July 22, 2022

Re: The Grove at 421

This department has reviewed the plan you submitted for The Grove at 421 swimming pool to be constructed at 61 Grove Circle in Lillington. This plan review was conducted in accordance with the current North Carolina Rules Governing Public Swimming Pools (15A NCAC 18A .2500).

71375⁺ PANEL, SERIES A
 2'CH 48" RESIDENTIAL FLUSH BTM

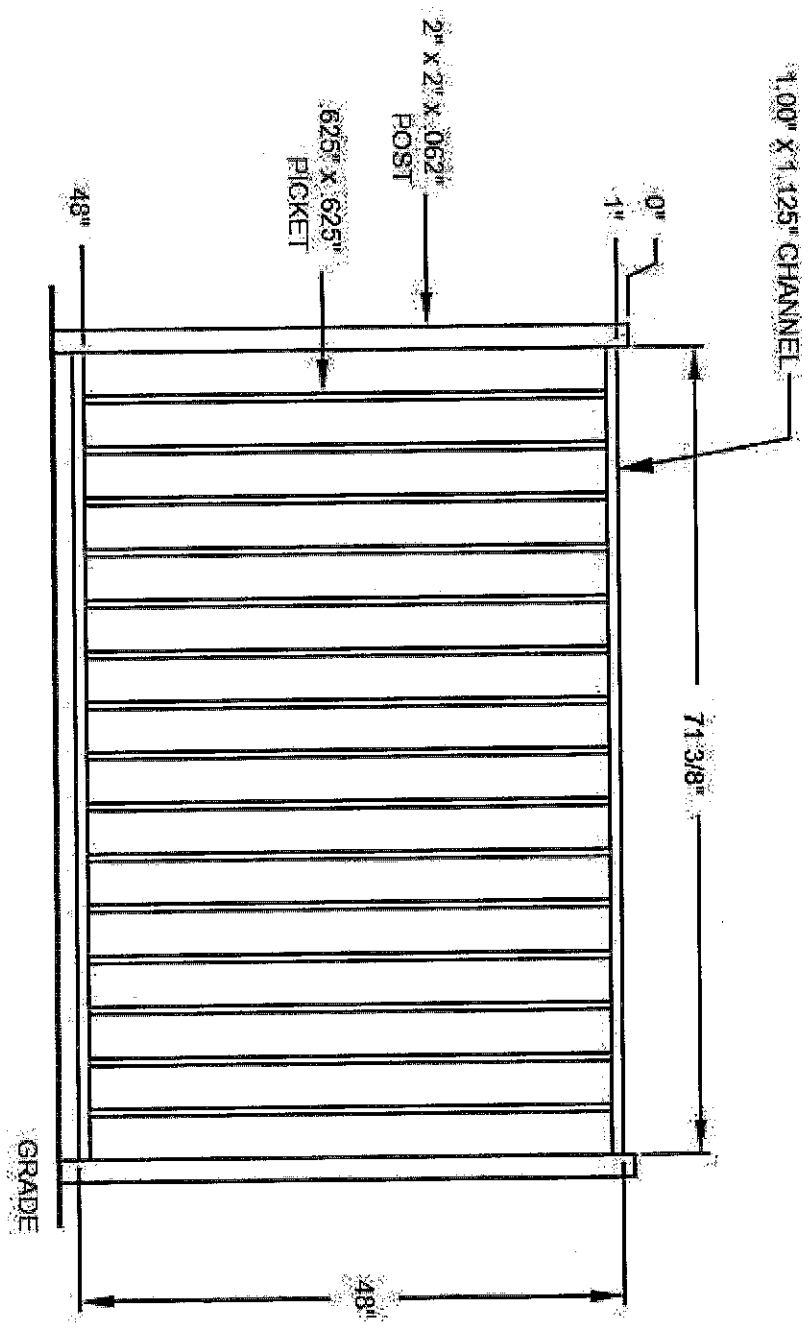
-Fencing must maintain a minimum of 48" even with the addition of landscape products such as mulching.

**2 A2 PUMP/CHEMICAL STORAGE ROOMS**  
SCALE: 1/2" = 1'-0"

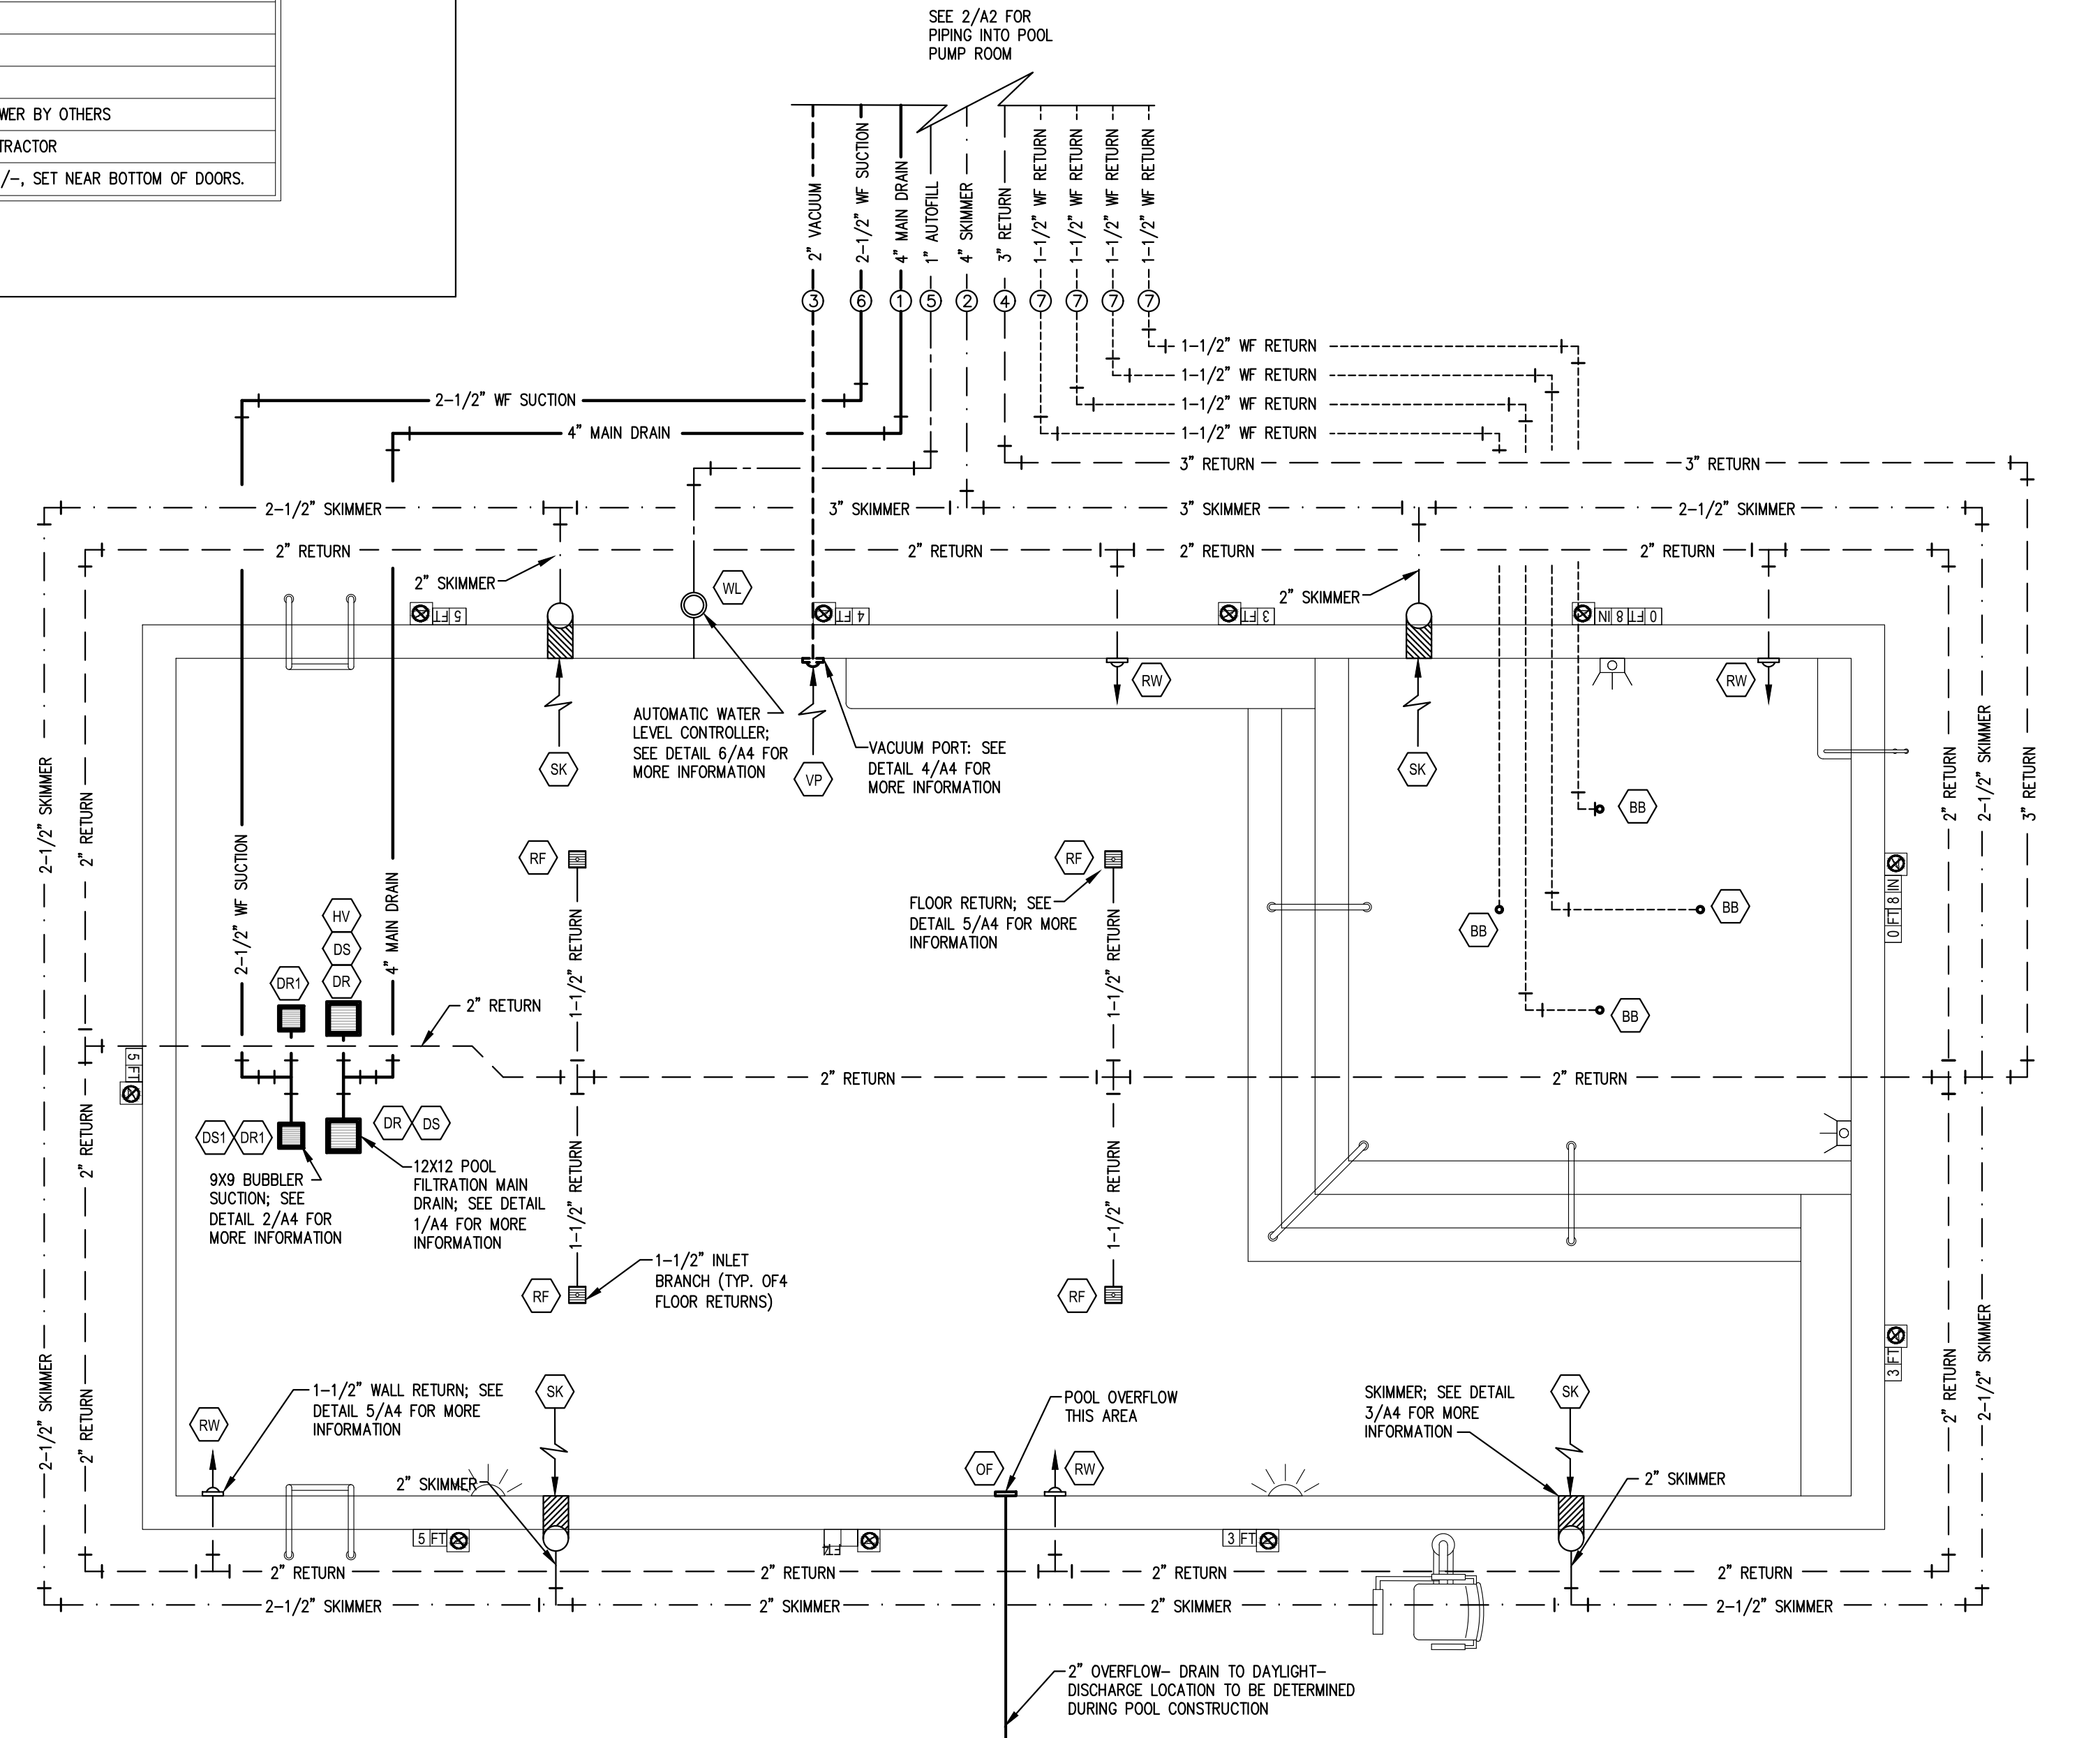
-As discussed in same conversation, all chemical feeder pumps will be installed such that if main circulation pump power is interrupted the feeder pumps will cease operation.

-Pump room will be fitted by builder per plans submitted by Clayton Britt and Sons.

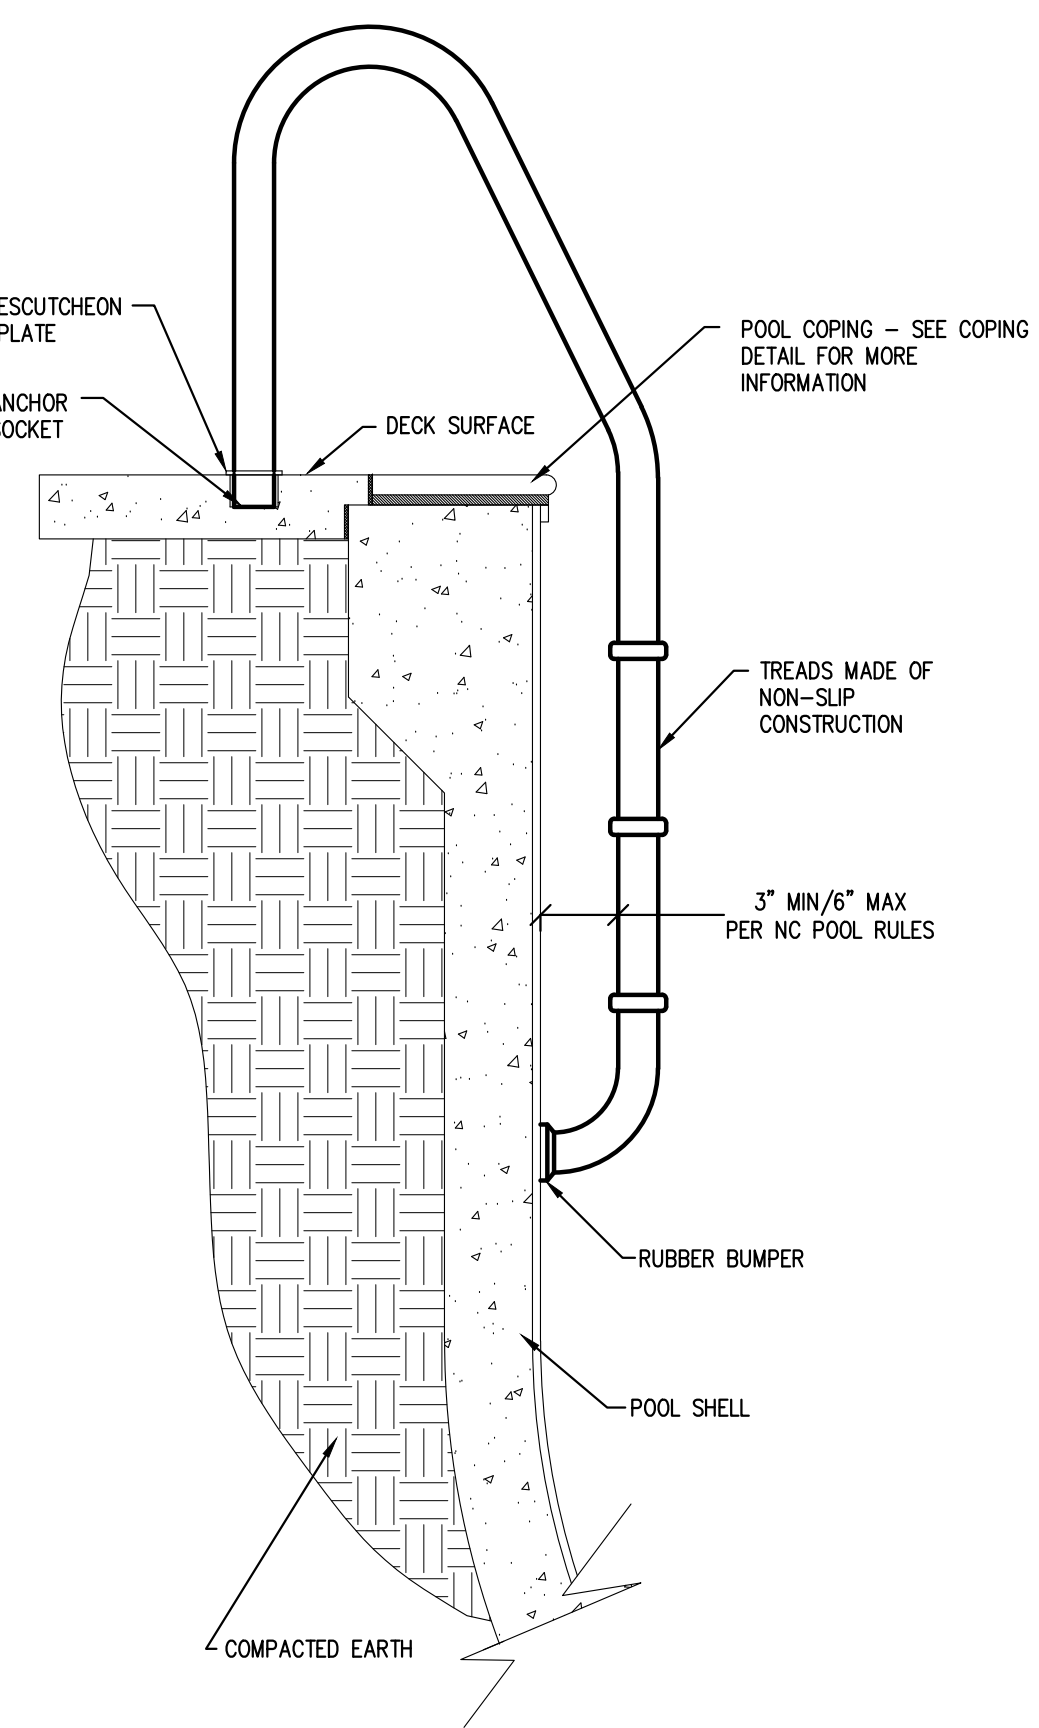
-Please contact the Environmental Health office prior to covering sumps so a visual inspection of the sump can be made.
